PLANNING CONSULTATION RESPONSE

Application No	2026/0244
Proposal	Demolition of existing building and septic tank and erection of new single storey community and sports pavilion, reconfiguration of parking, new landscaping and other associated works.
Address	Rabbit Ings Country Park, Lund Hill Lane, Royston, Barnsley, S71 4BB
Date of Consultation Reply	21/07/2026
Consultee	Highways Development Control

The proposal seeks to replace the 111m² GFA existing visitor centre with a new and improved facility of 202m² GFA with revised parking arrangements.

TITLE
Proposed Site Plan

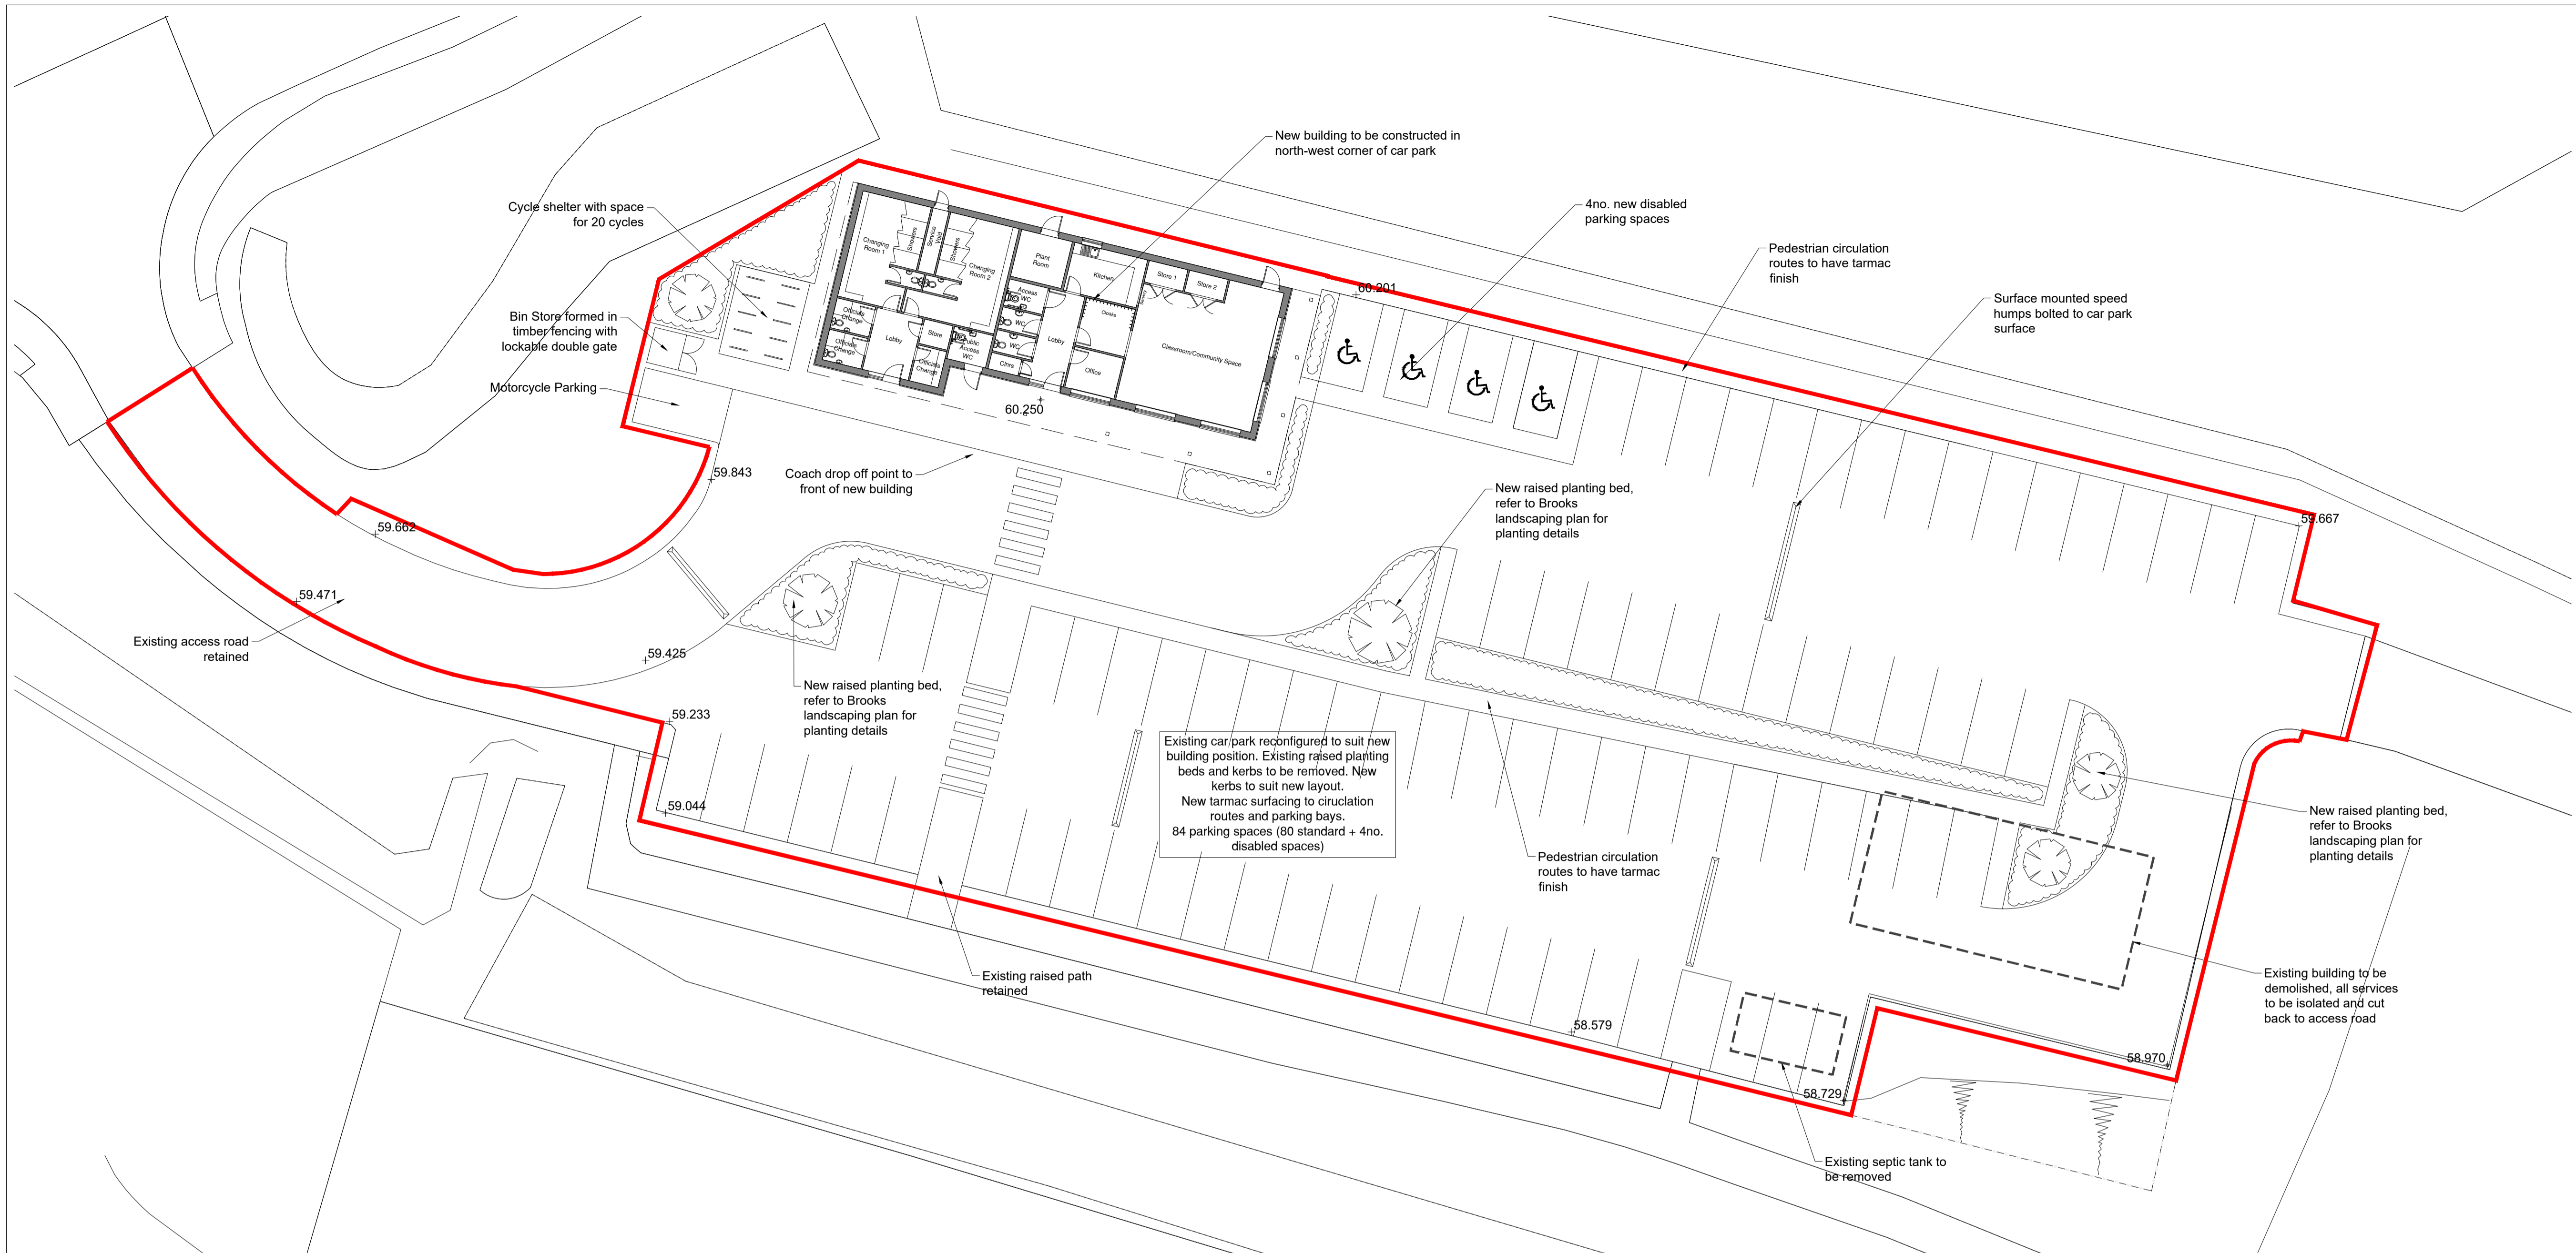
Whilst the principle of providing motorcycle parking is supported, the proposed provision of three motorcycle spaces is considered insufficient, in addition the submitted drawings do not provide details of suitable anchoring facilities to ensure motorcycles can be securely parked. The expected level of parking is 1 m/cycle space per 20 car parking spaces and therefore a further space is required, totalling 4 spaces incorporating suitable access points. Given the scale of works required, this matter can be satisfactorily addressed via a planning condition.

Prior to the first occupation/use of the development, a minimum of four motorcycle parking spaces shall be provided and made available for use. Each space shall be equipped with a secure ground anchor point suitable for locking motorcycles. The motorcycle parking facilities shall be retained and kept available for their intended purpose for the lifetime of the development.
